From: Laura Gibbons <Laura.Gibbons@arun.gov.uk>
Sent: 21 September 2021 08:16
To: Planning.Responses <Planning.Responses@arun.gov.uk>
Subject: RE: Planning Consultation on: A/168/21/PL

Engineers Comments Regarding Surface Water Drainage

Application No: A/168/21/PL

Description of Works: Erection of 76 No. dwellings, means of access, public open space, play areas, associated infrastructure & landscaping. This application is a Departure from the Development plan, is in CIL Zone 5 and is CIL Liable as new dwellings & affects a Public Right of Way.

Preliminary Drainage Strategy

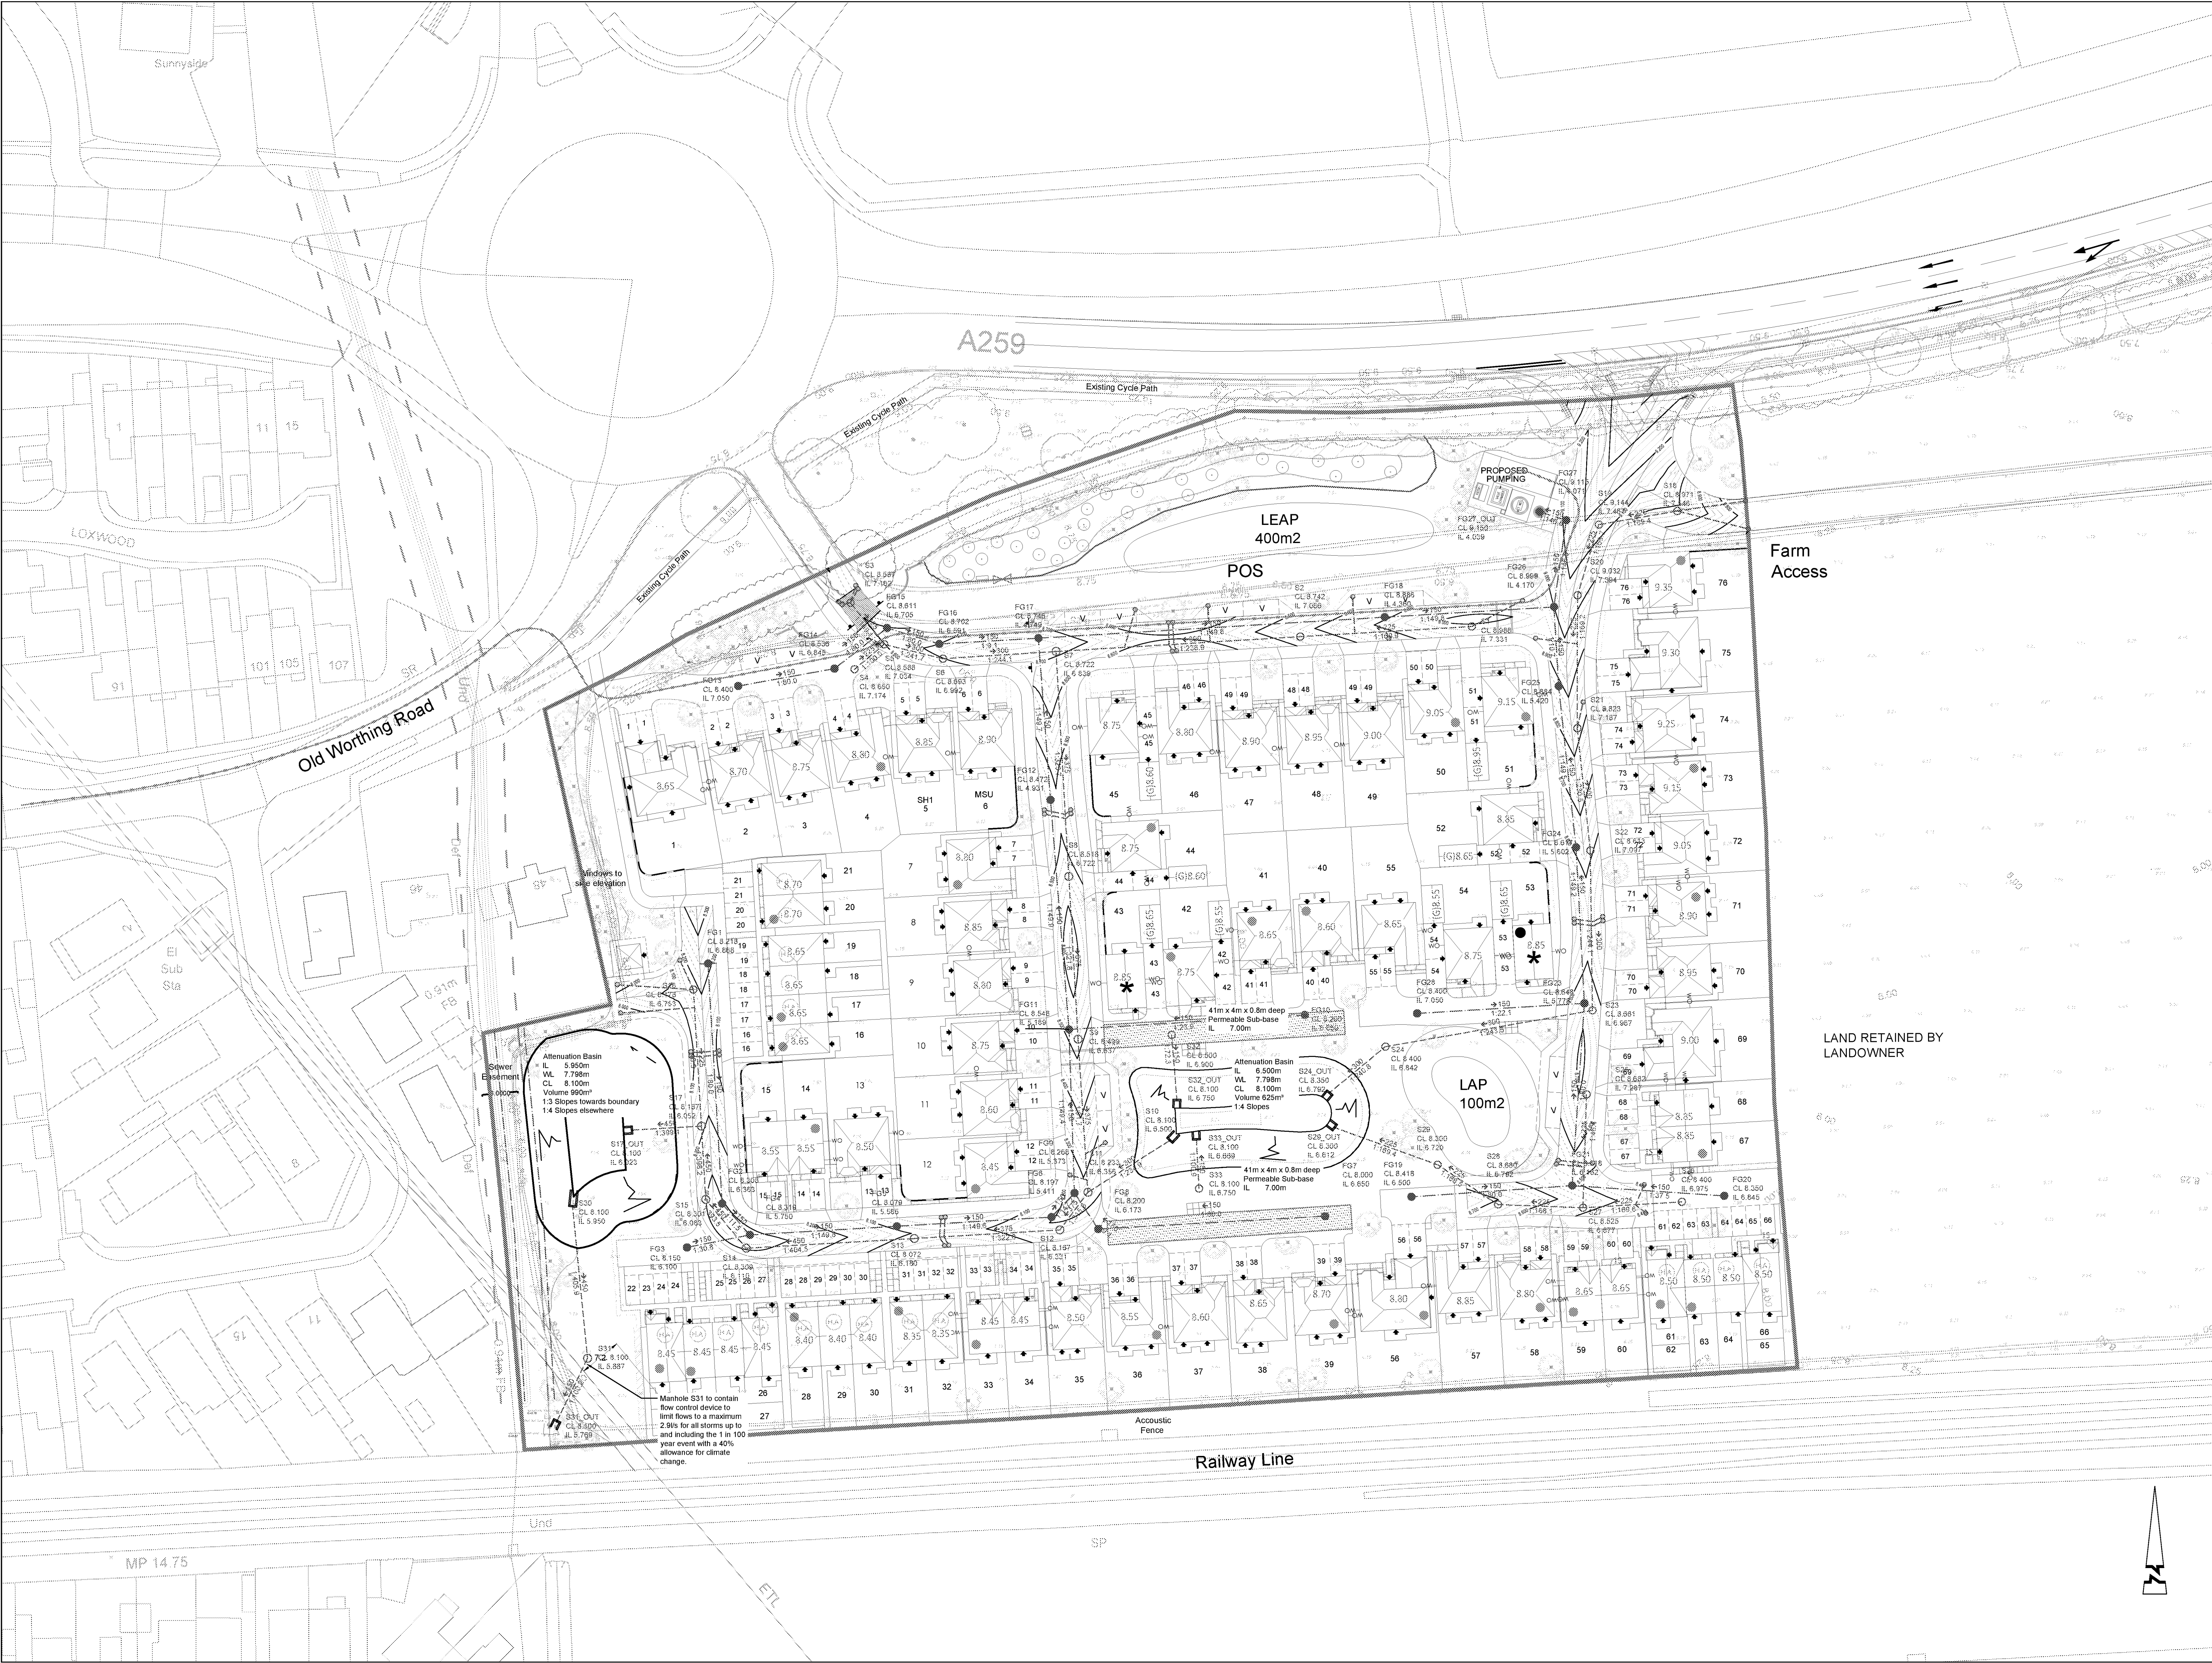
A surface water drainage strategy has been submitted with this application. The strategy identifies an attenuation drainage strategy with discharge limited to 2.9l/s. We note that winter groundwater monitoring has been completed and ground water was found at just over 1m depth throughout the site. Winter infiltration testing was completed, but three repeat tests were not completed at any location. The single test completed at each location indicate that infiltration is viable here. Full winter infiltration testing in accordance with BREDG365 must be completed.

The drainage strategy must follow the hierarchy for sustainable drainage. If infiltration is viable we expect it to be used. Given the infiltration rates found so far it is likely that a shallow blanket infiltration system with high level overflow to ditch will be required. This may impact upon layout. Saying that infiltration will not fit within a layout is insufficient justification for not following the hierarchy.

Permeable paving, shallow conveyance and infiltration features are likely to be required on this site. We wish to see a considered infiltration drainage strategy design showing how this will fit in with the proposed layout.

We note that soft landscaping proposals include numerous trees within close proximity of both pipework and basins. Trees must be positioned so that their root potential areas do not conflict with drainage proposals. It should also be noted that attenuation features should not be counted within useable public open space provision.

On the assumption that a connection to the watercourse is required, offsite improvements to ditches and culverts are required to facilitate a formal discharge. This was discussed at a site meeting between ADC and the developer and is referenced within the FRA/Drainage Strategy. The details of these improvements will need to be agreed as a part of the process of discharging planning conditions.

The watercourse on the western boundary would appear to have been culverted in part without permission. Removal of the culvert and subsequent ditch reinstatement will need to be agreed, again when discharging planning conditions.

- A revised surface water drainage strategy, including layout and calculations, demonstrating how an infiltration drainage solution can be provided within the proposed layout.
- Revised landscaping proposals removing conflict between trees and drainage.
